About the application

Application number: 2026/91547	
What is the application for?:	Change of use of residential dwelling (Use Class C3) to childrens care home for
Address of the site or building:	28, Sylvan Ridge, Huddersfield, HD2 1ZH
Postcode:	HD2 1ZH

Type of comment: An objection	
Do you wish your comments to be published on the website anonymously?	Yes

BLOCK PLAN

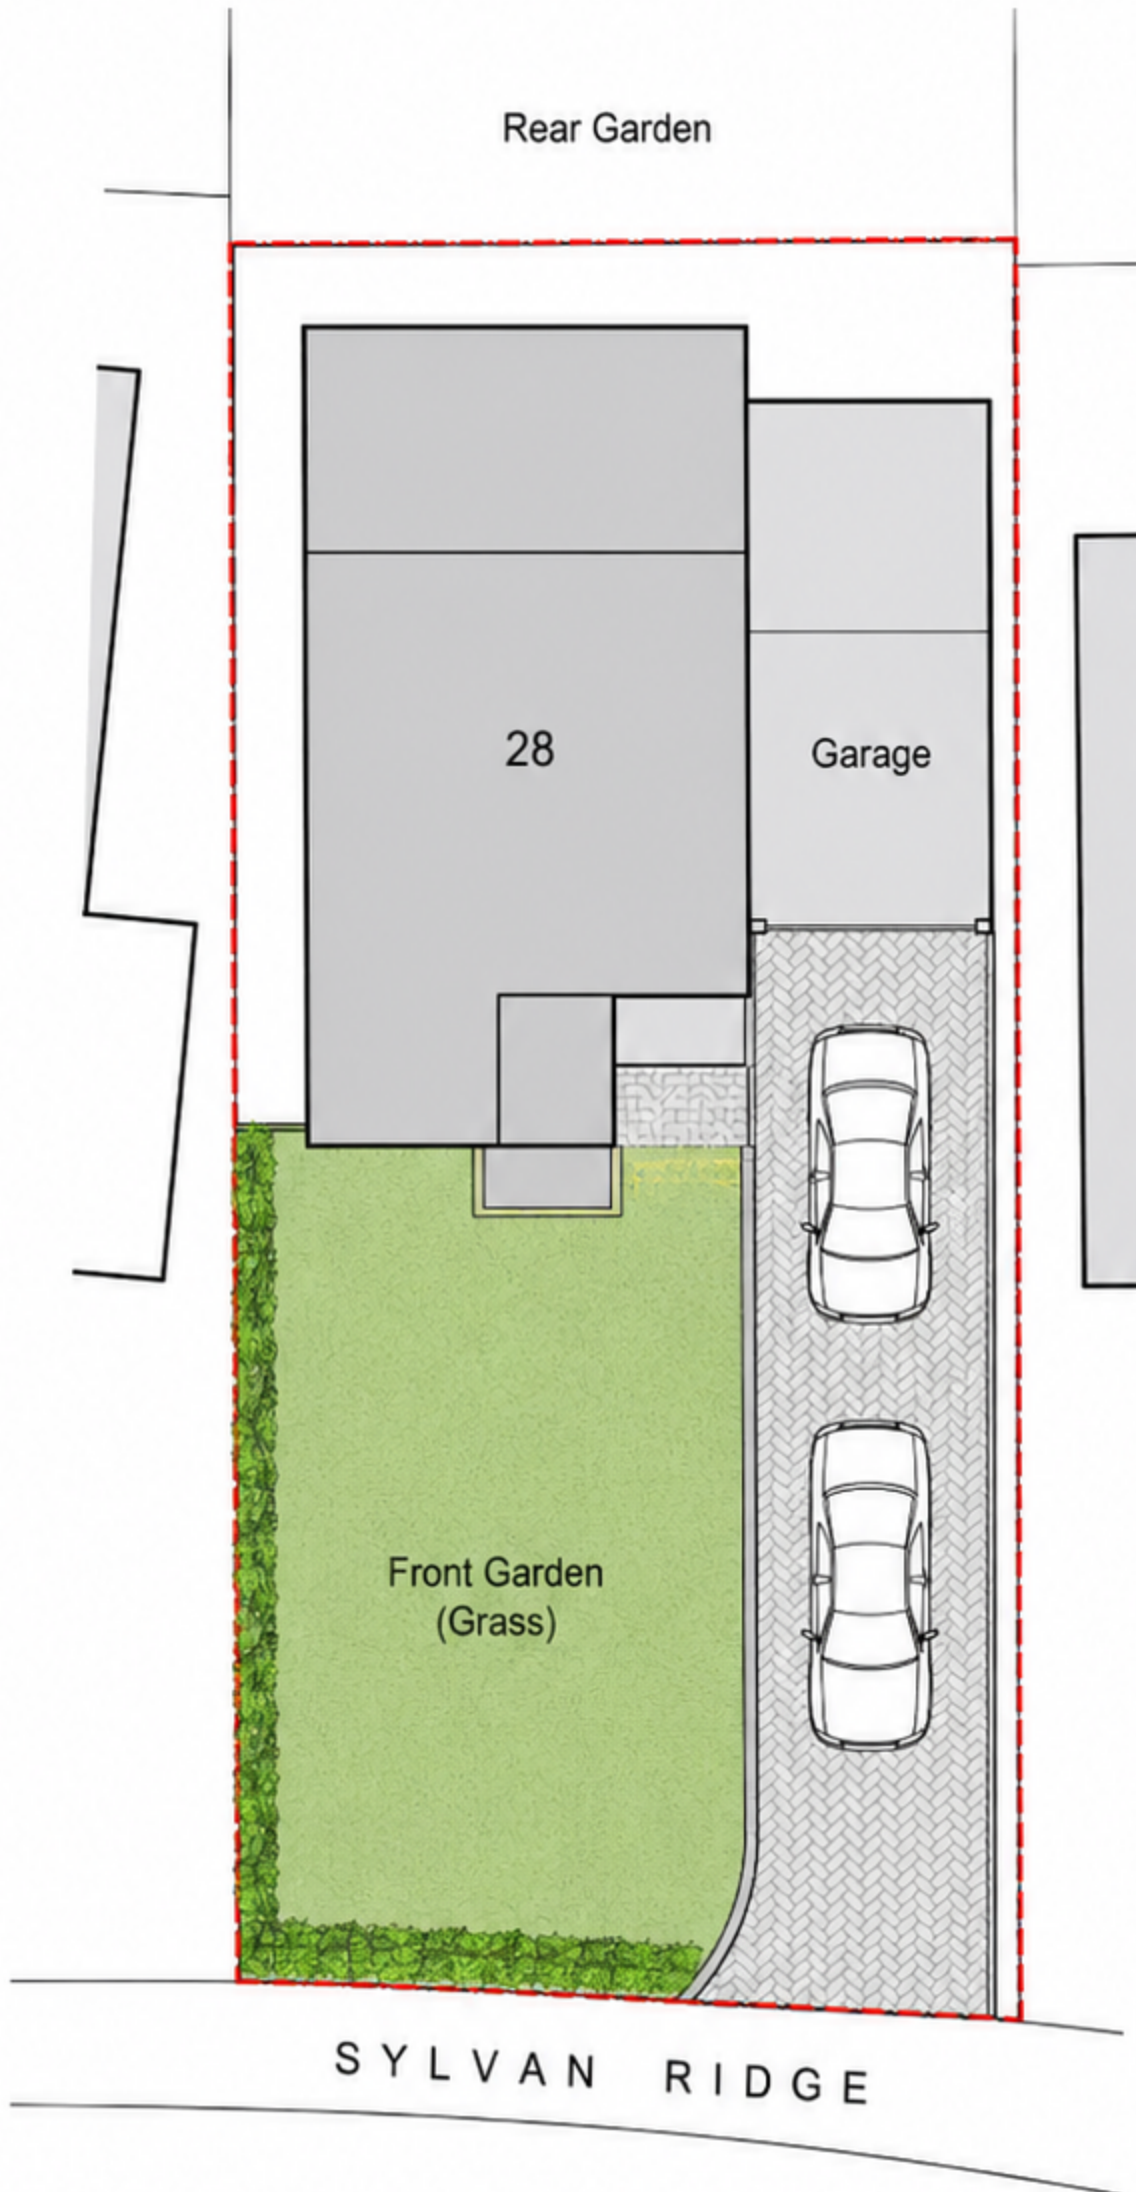
2. The application contains incorrect and misleading information regarding the existing outside of the property and surrounding area. One of the plans submitted showing the location of the property is not the correct street, although it states it is Sylvan Ridge the property highlighted on the plan is not 28 Sylvan Ridge, this is very misleading as it does not show the property backs directly onto Lower Fell Wood. There are other inaccuracies in addition.
